NEW MEXICO VIETNAMESE BUDDHIST ASSOCIATION
HỘI PHẬT GIÁO VIỆT NAM TẠI NEW MEXICO
QUANG MINH TEMPLE
CHÙA QUANG MINH
420 Pennsylvania SE, Albuquerque, NM 87108. Phone: (505) 265-7299

December 9, 2014

This letter specifies that all modifications have been made to the site plan to meet each of the EPC conditions:

SITE DEVELOPMENT PLAN SUBMITTAL

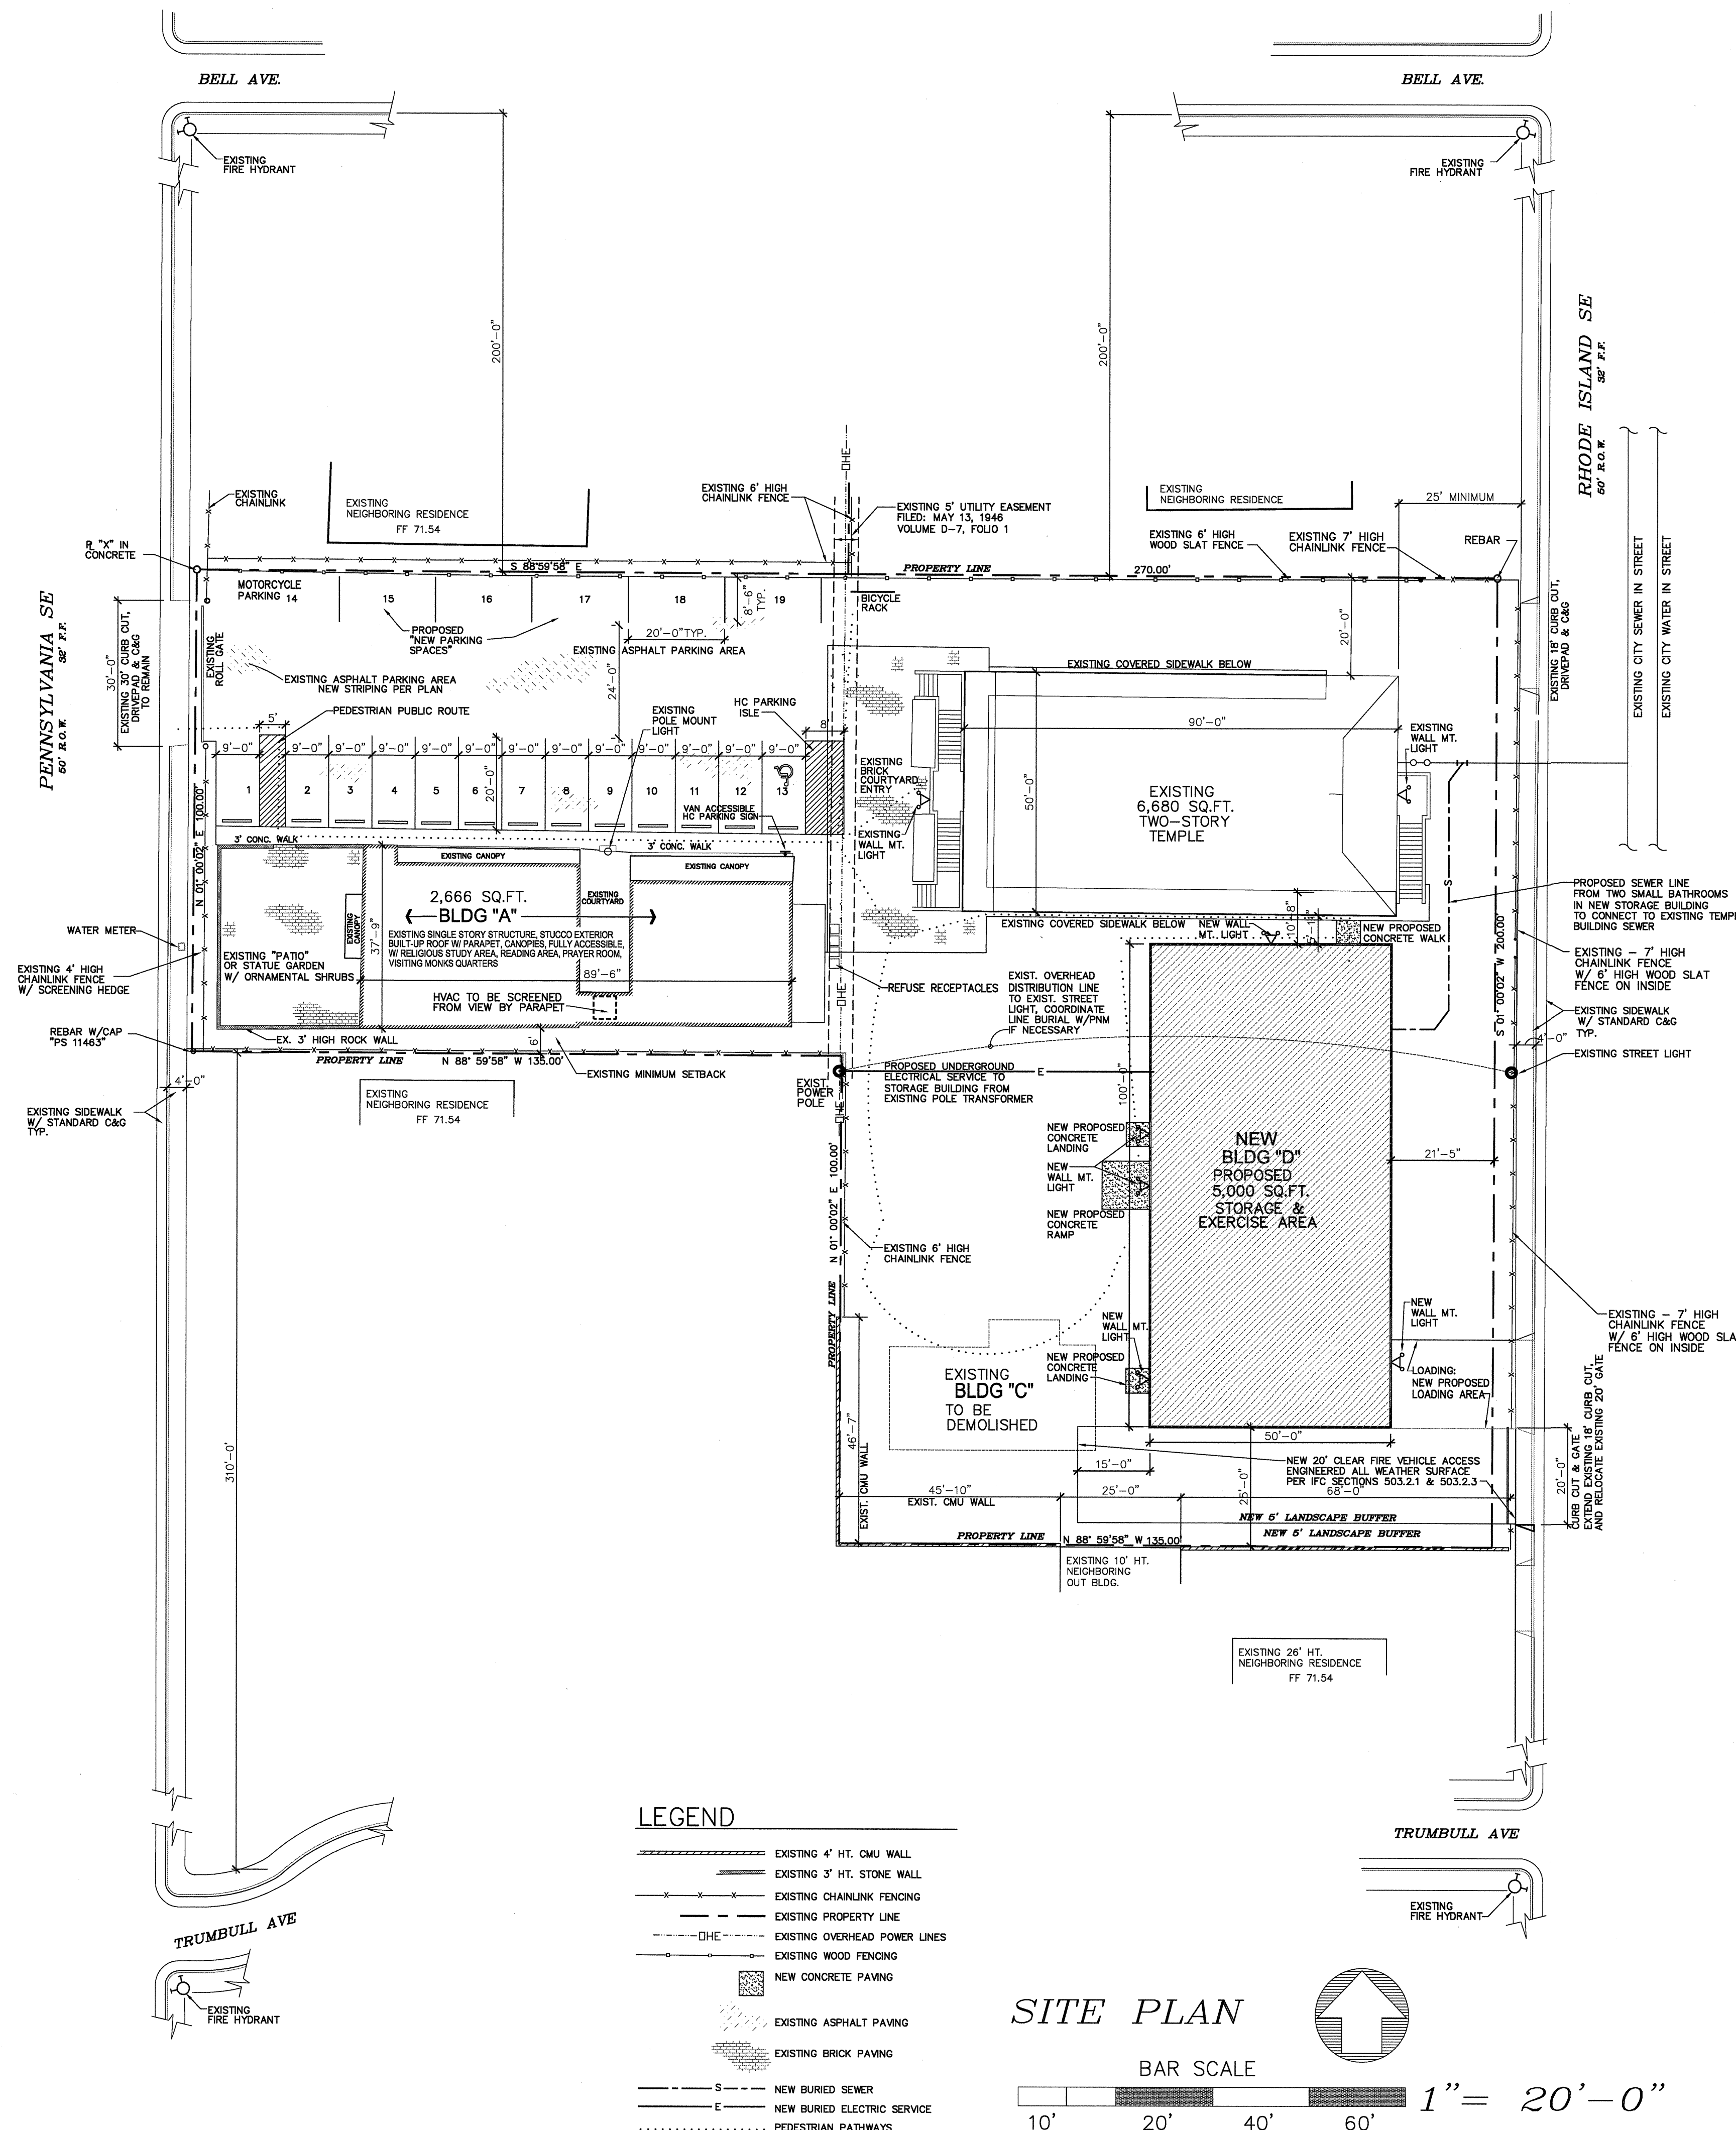
- Due to the proximity of the proposed building to the surrounding residential area, a note shall be included on the site development plan for building permit that states that all proposed motion detected / photo sensor light fixtures will not shine directly on any public right-of-way or other residential premises and shall conform to area lighting requirements as regulated by Section § 14-16-3-9 (Area Lighting Regulations) the Zoning Code
The site plan has been modified to reflect the changes suggested in condition 3

LANDSCAPING PLAN

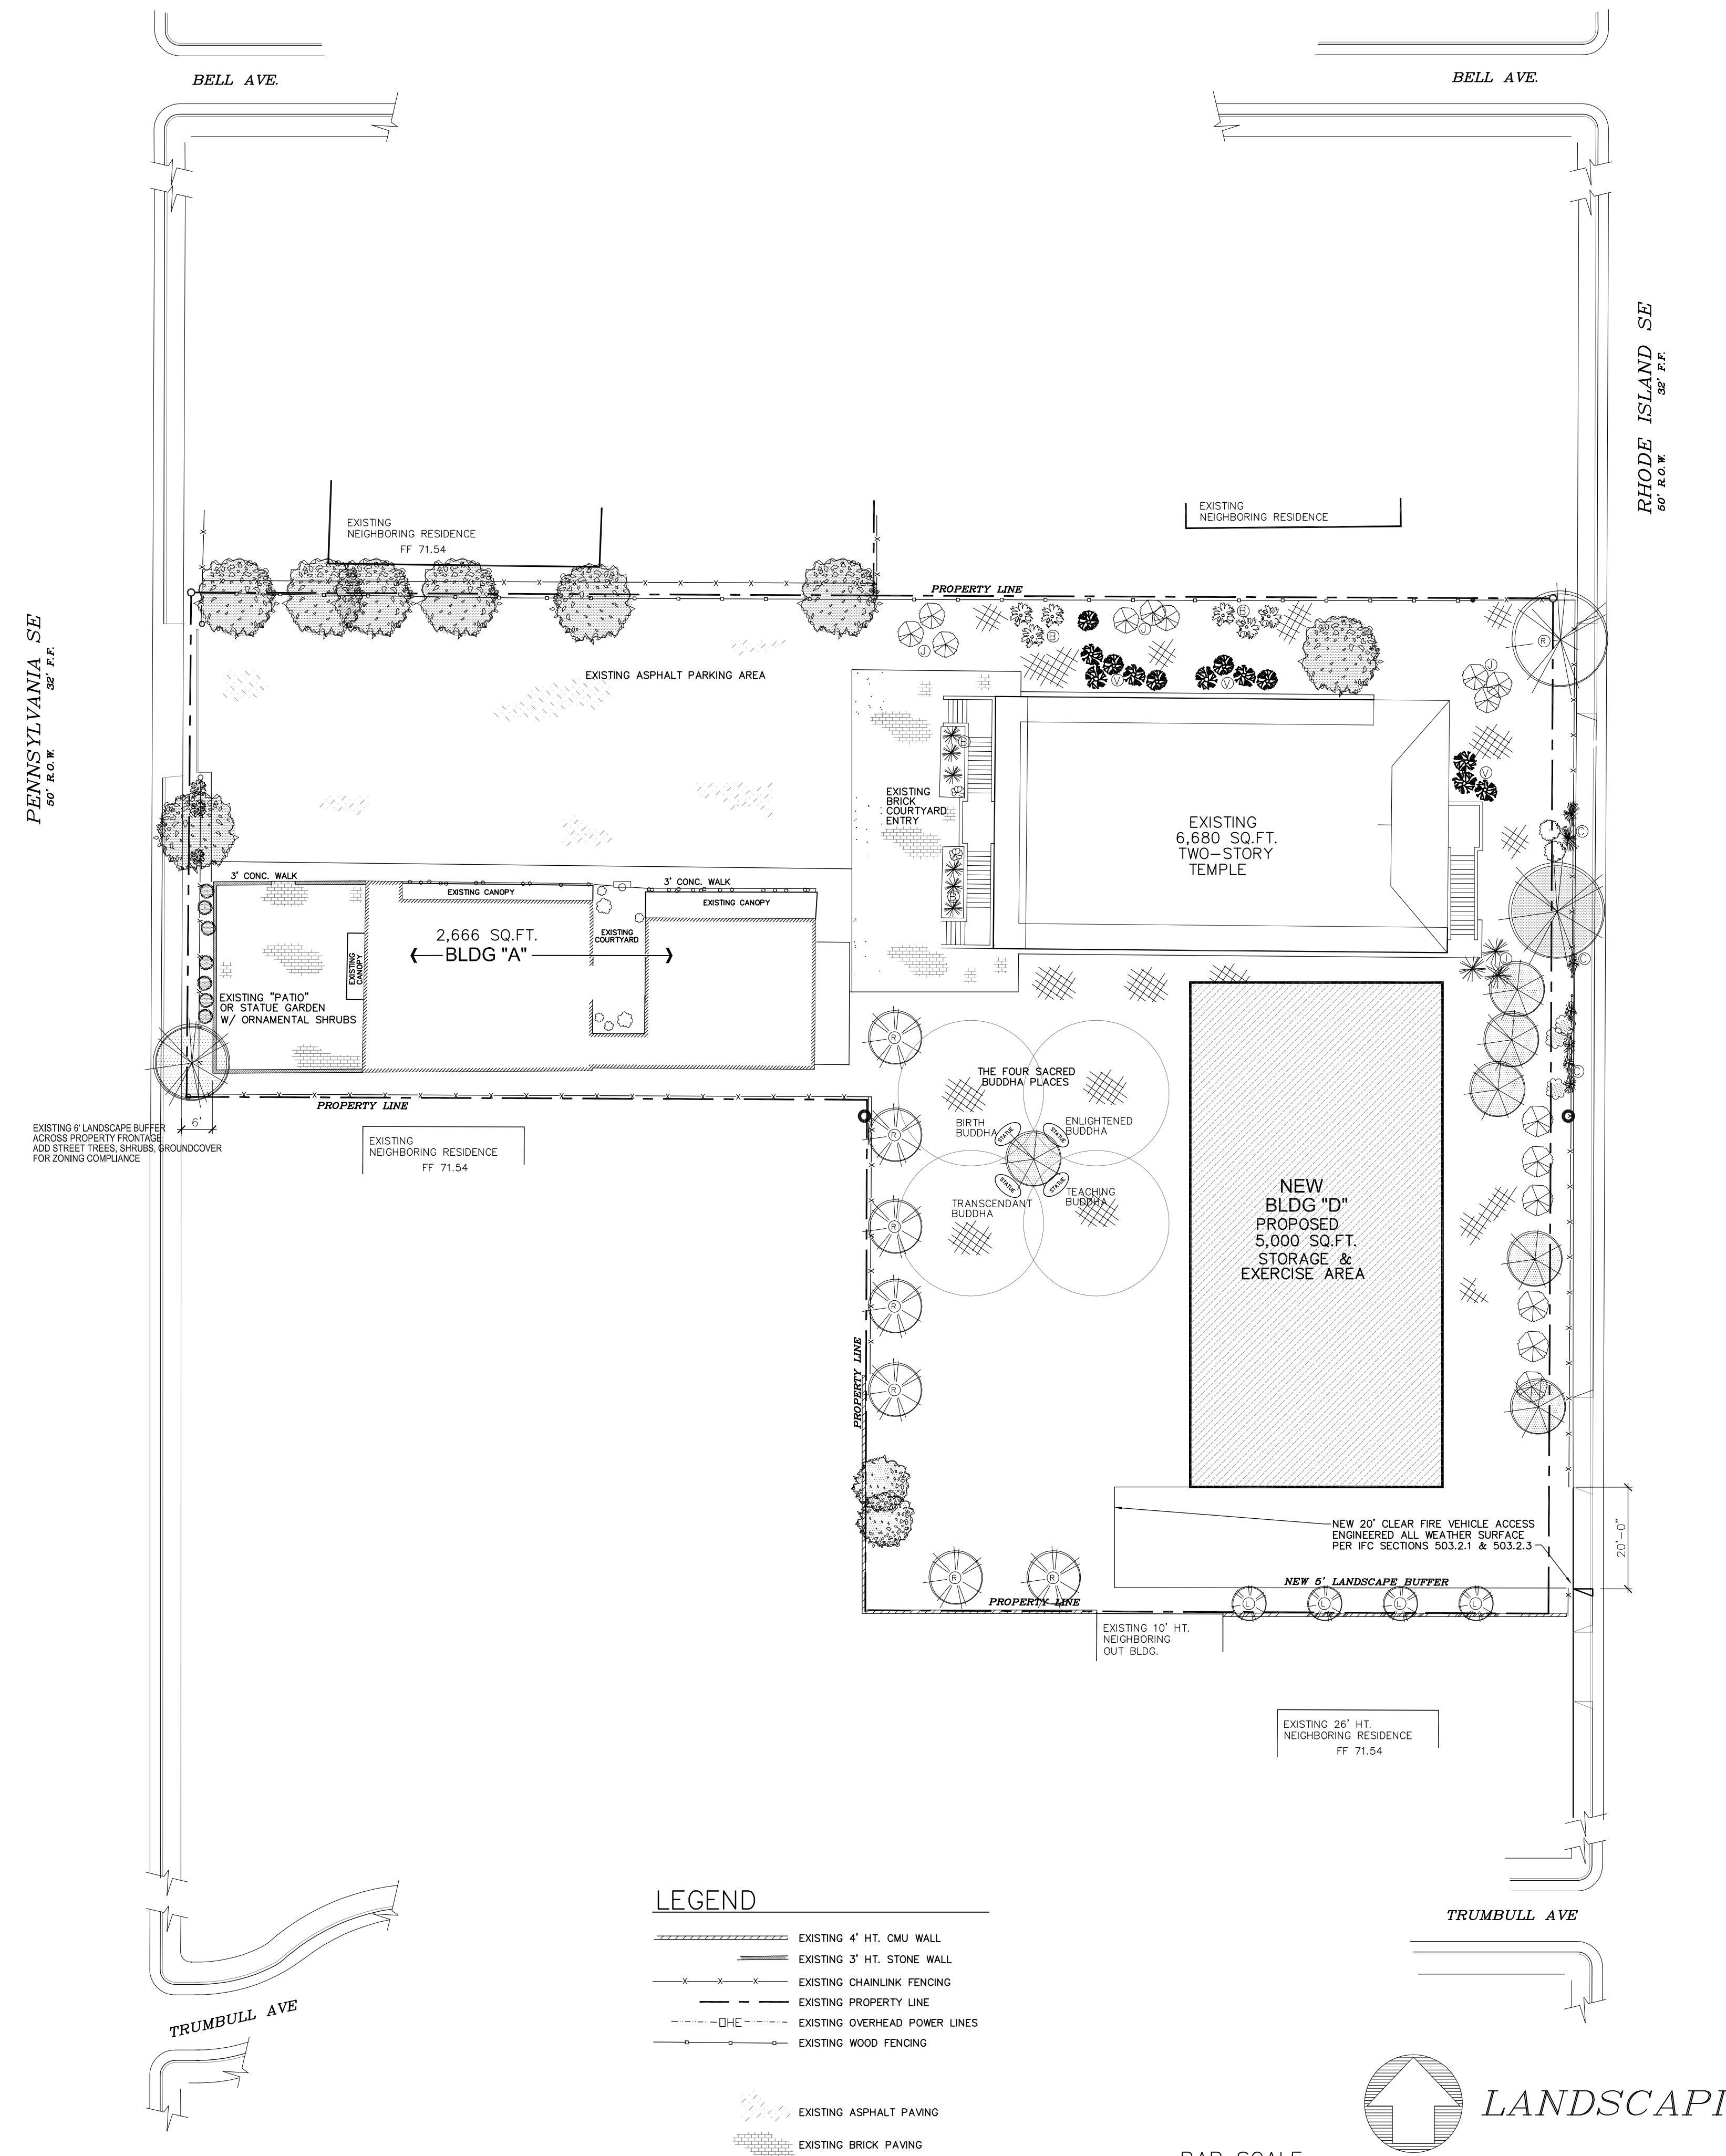
- Conditions of approval from Long Range Planning:
 - a. Additional buffer landscaping should be provided between this site and adjacent single family residential properties near the new building in order to be more consistent with the General Landscaping Regulations in the City Zoning Code.

The site plan has been modified to reflect the suggested changes.

**CONCEPTUAL GRADING AND DRAINAGE PLAN**

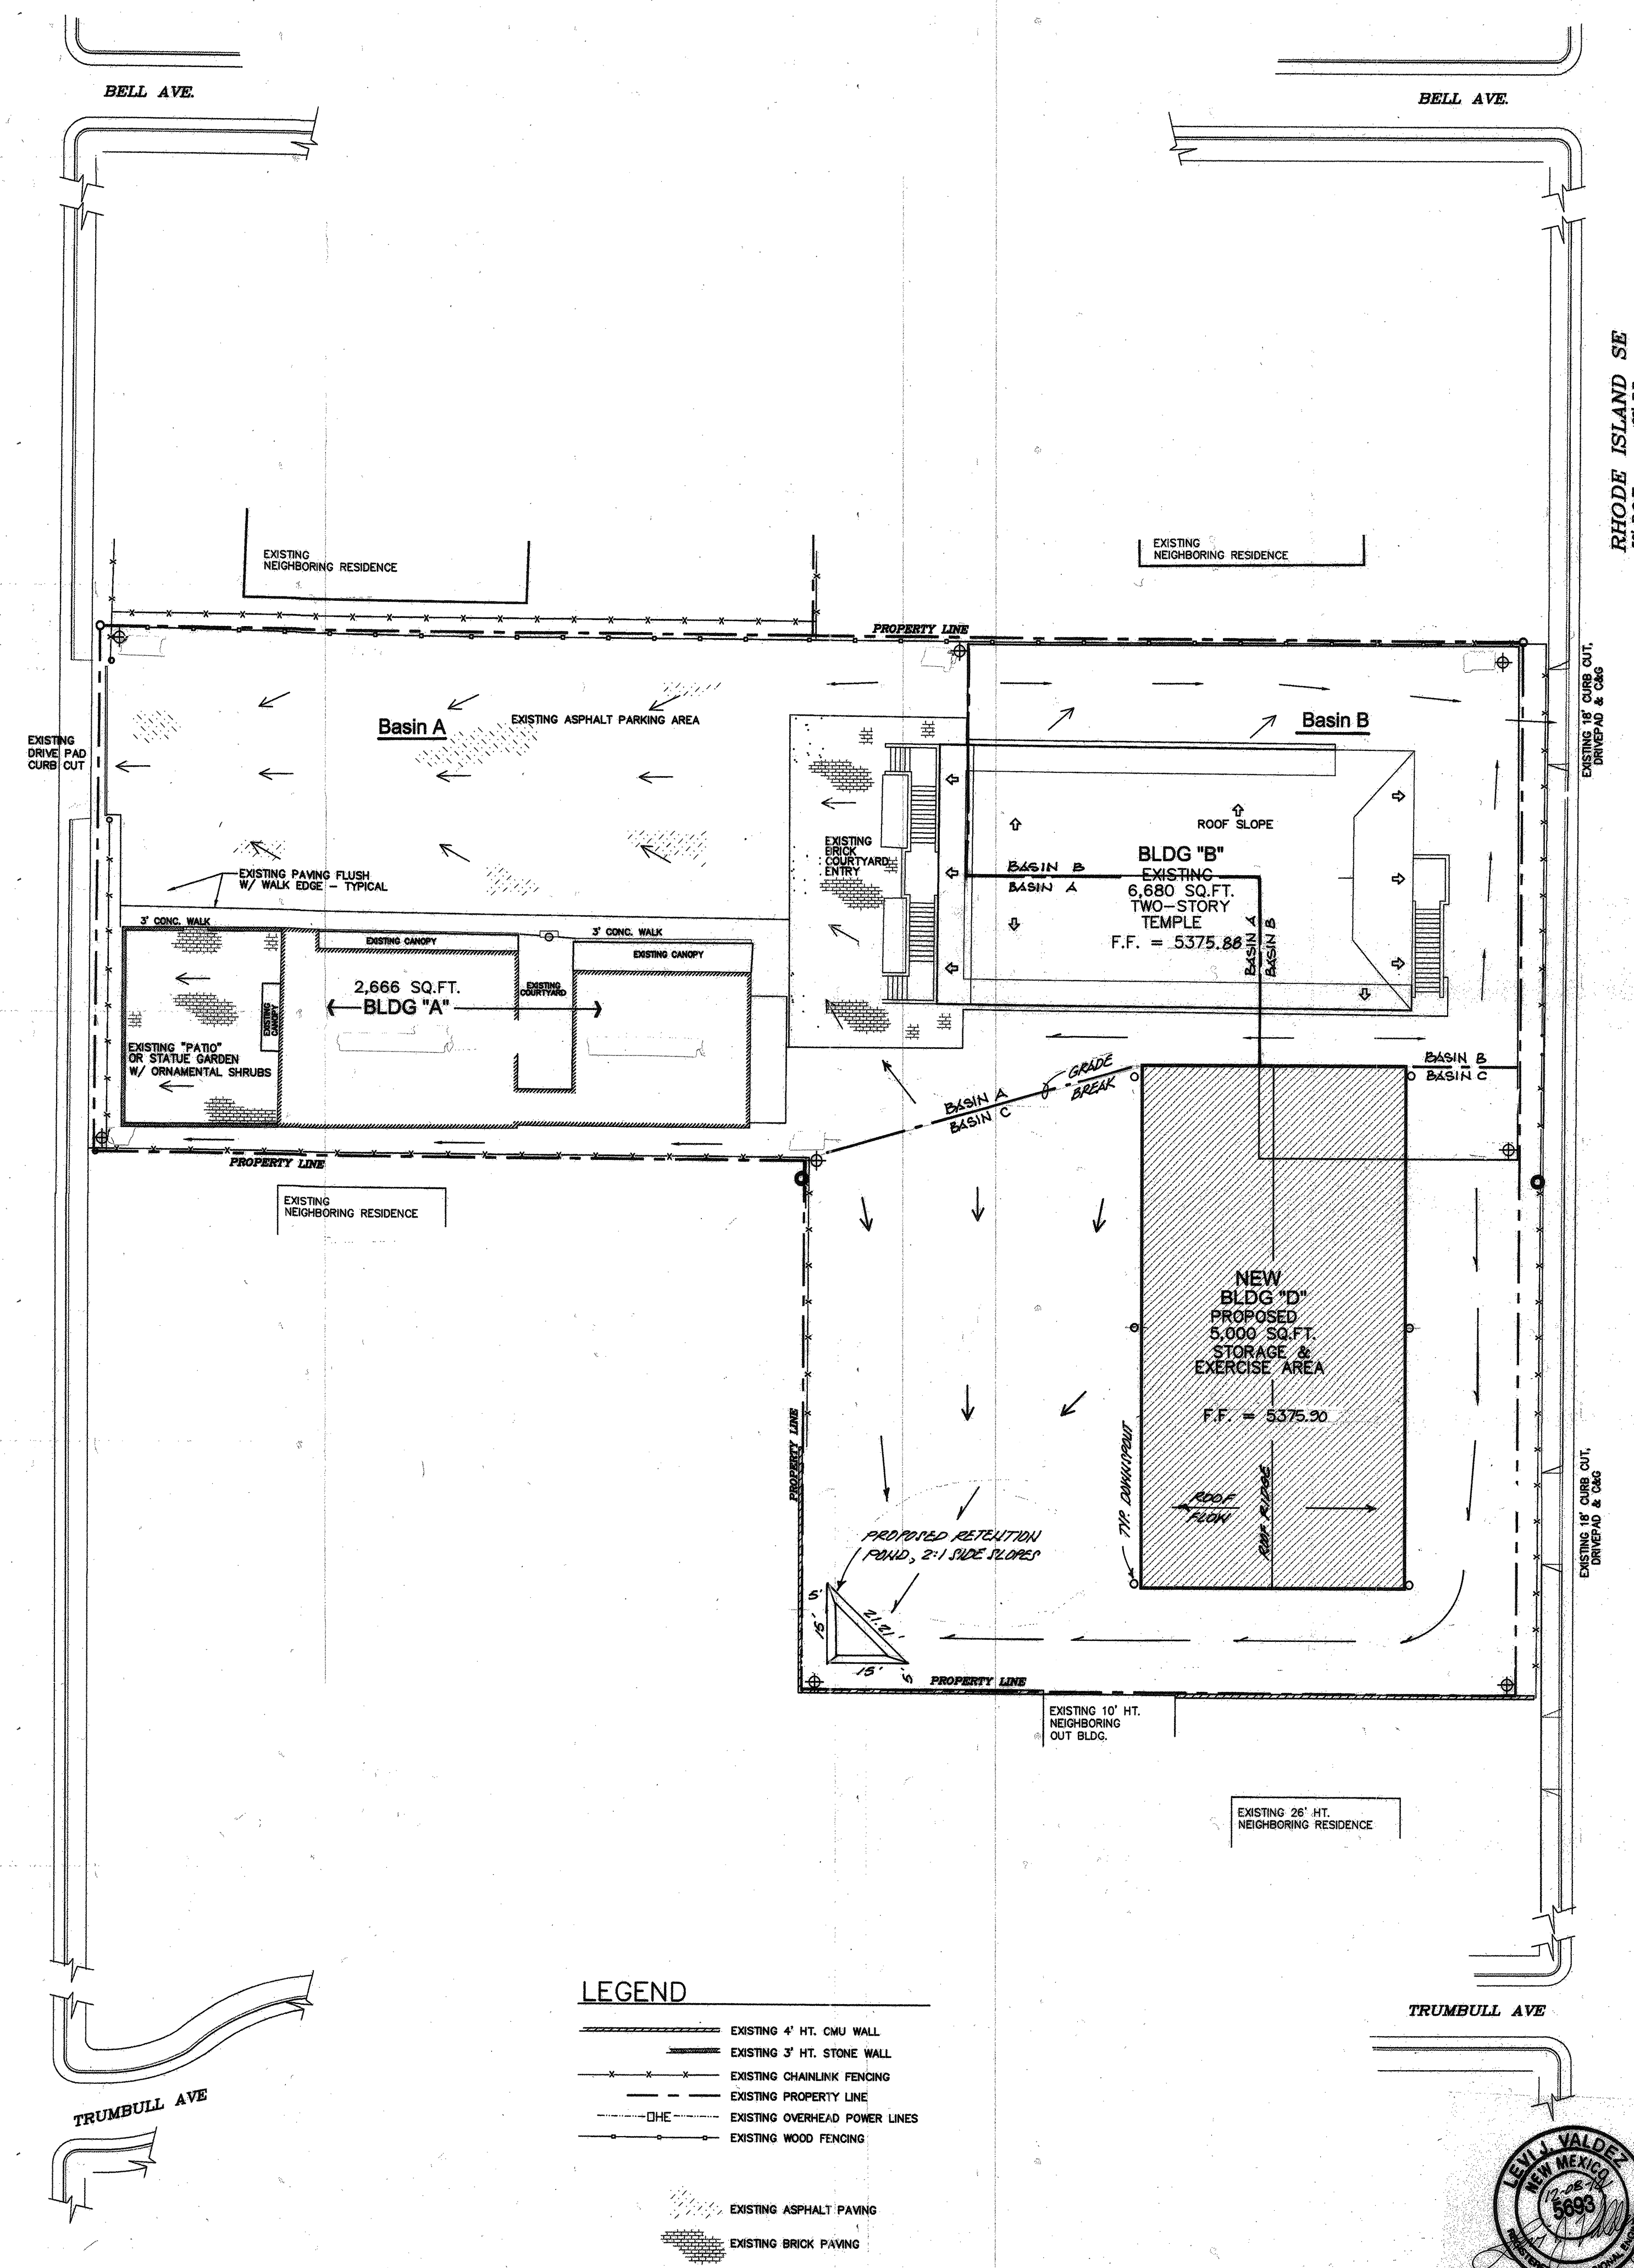
- Conditions of approval from Hydrology Department:
 - a. For DRB approval, submit a grading and drainage plan (can be conceptual) prepared by a NM Professional Engineer that includes details as to how the site will manage the first flush requirements.
Six (6) copies of 24"x 23" size of the conceptual grading drainage plan prepared by a NM Professional Engineer will be submitted
